Address: 180 Washington Ave

permit # 2014-01749

CHECK-LIST AGAINST ZONING ORDINANCE

Proposed Use/Work - build 64'x24', two residential condominiums

PROPOSED ELEVATIONS

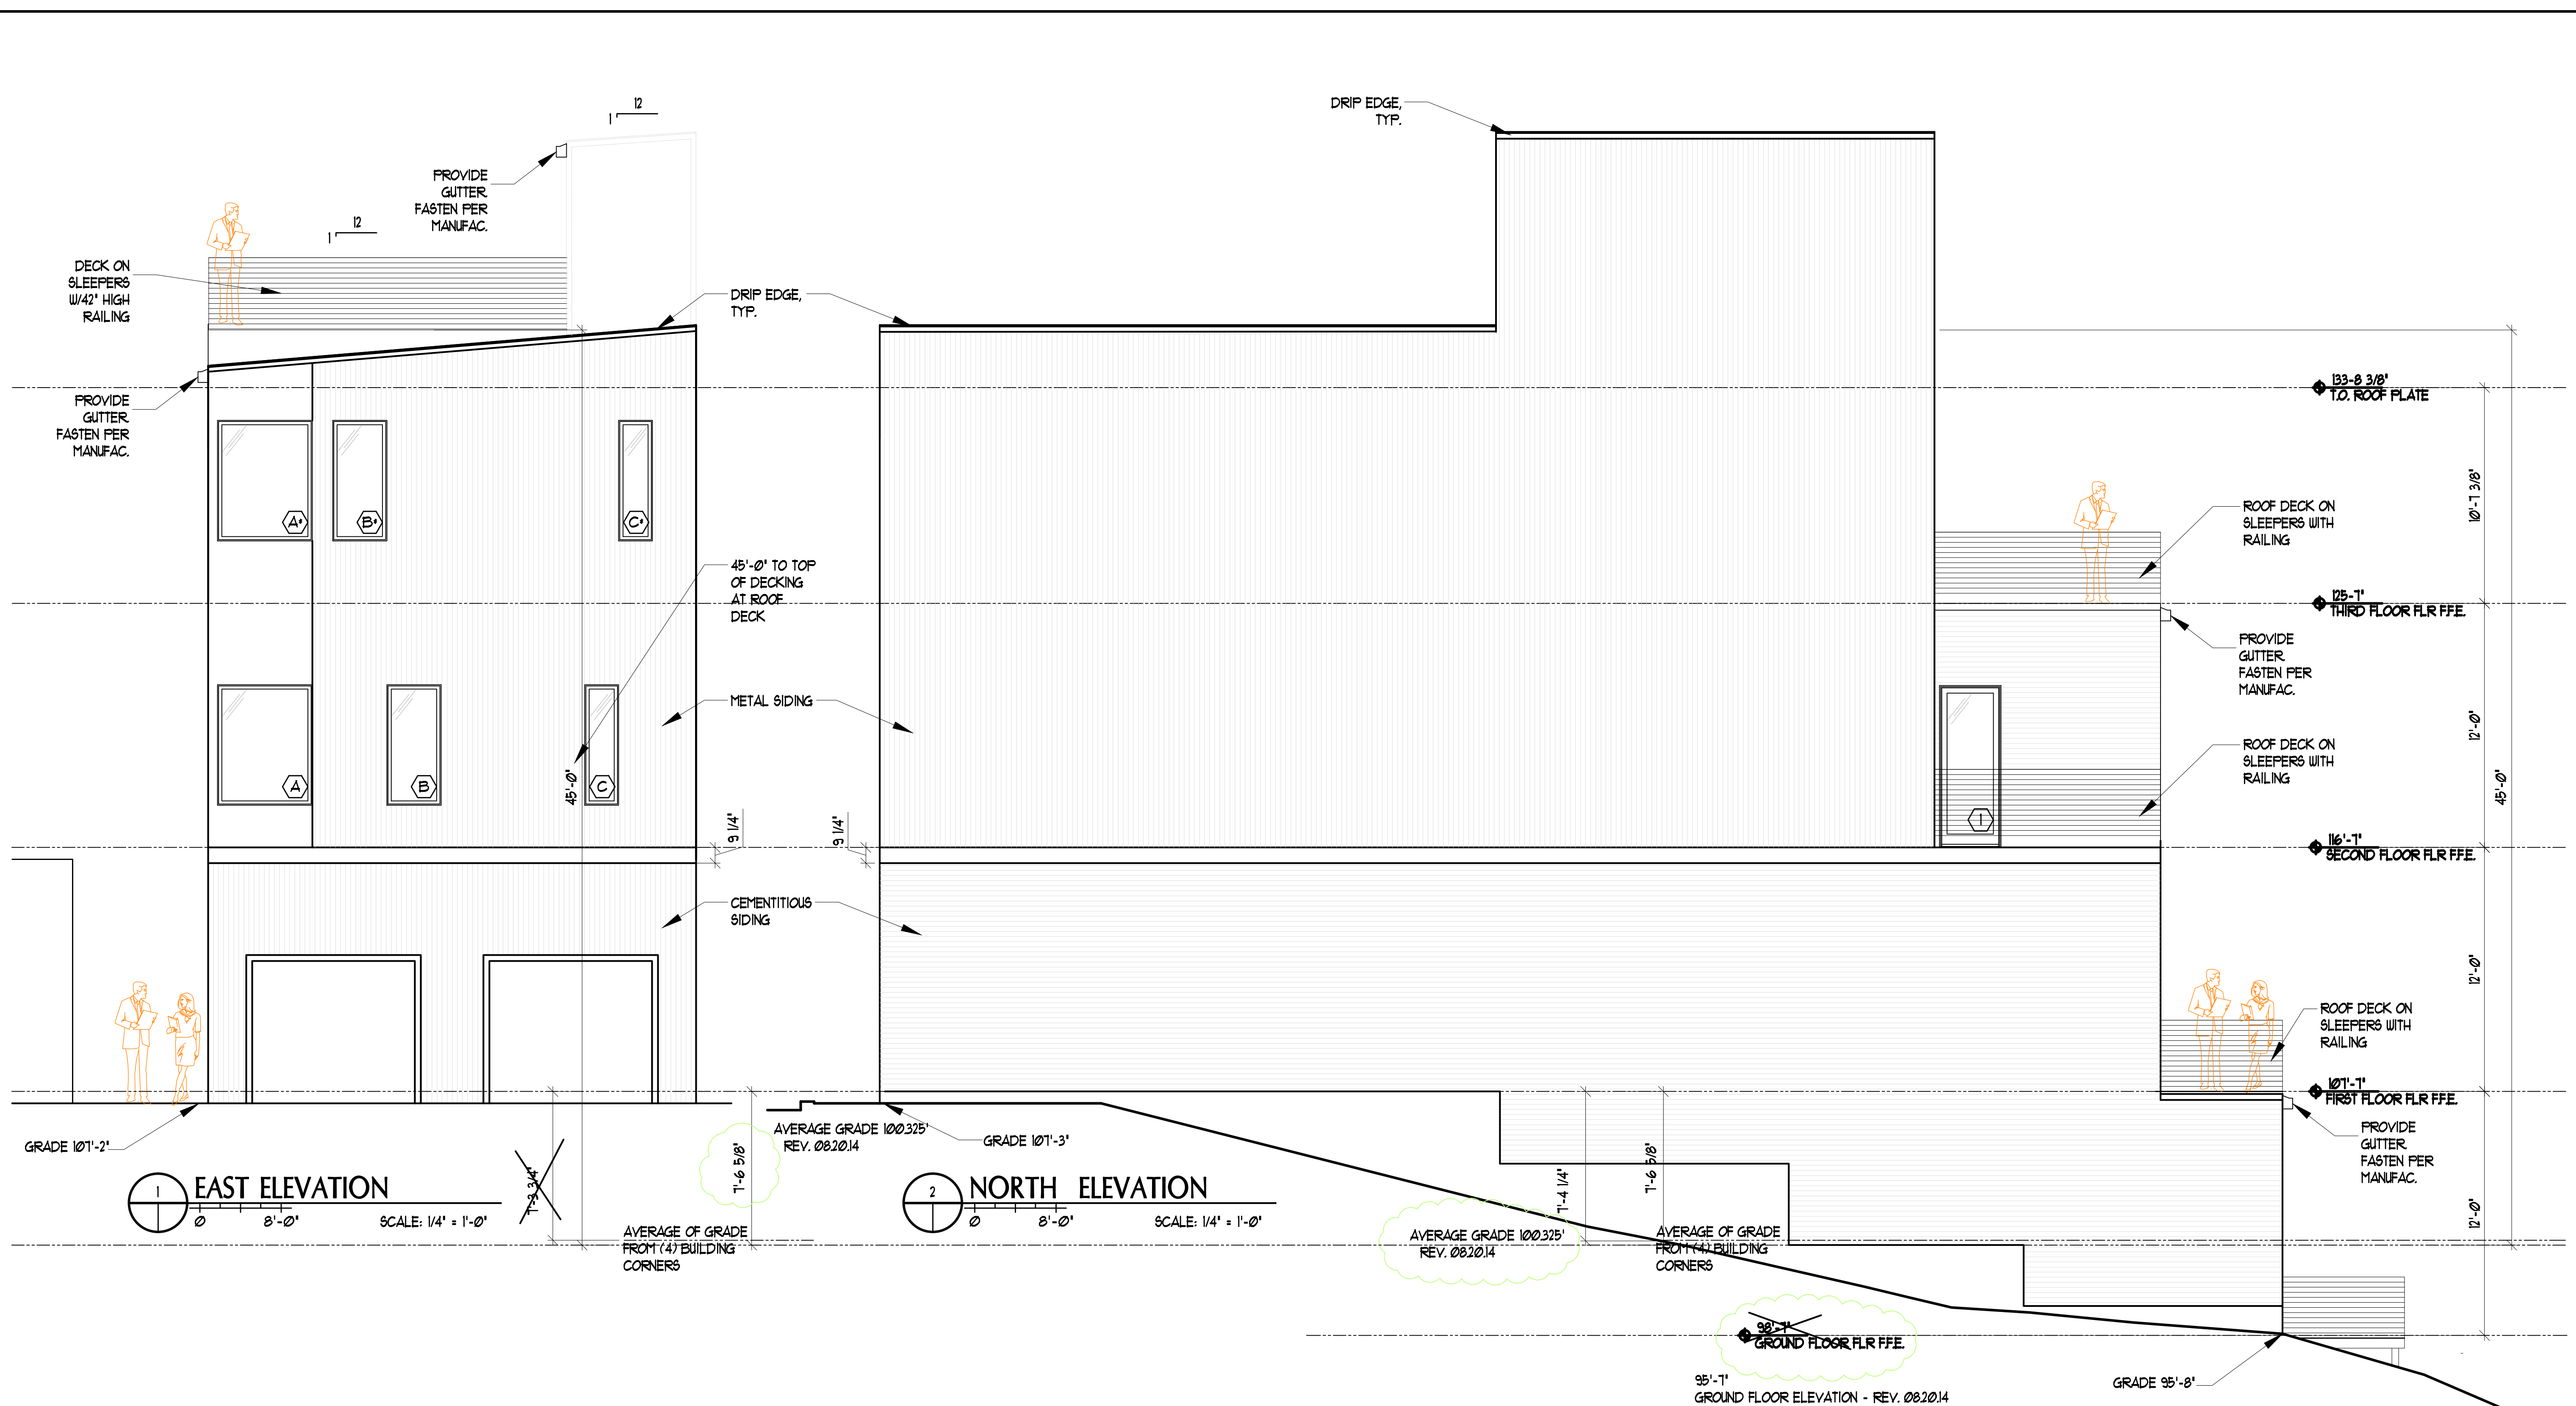
Height - 45' max. - 45' shown on elevation from 100.30' ~~225'~~ - to top of building OK
average grade is 101.125'
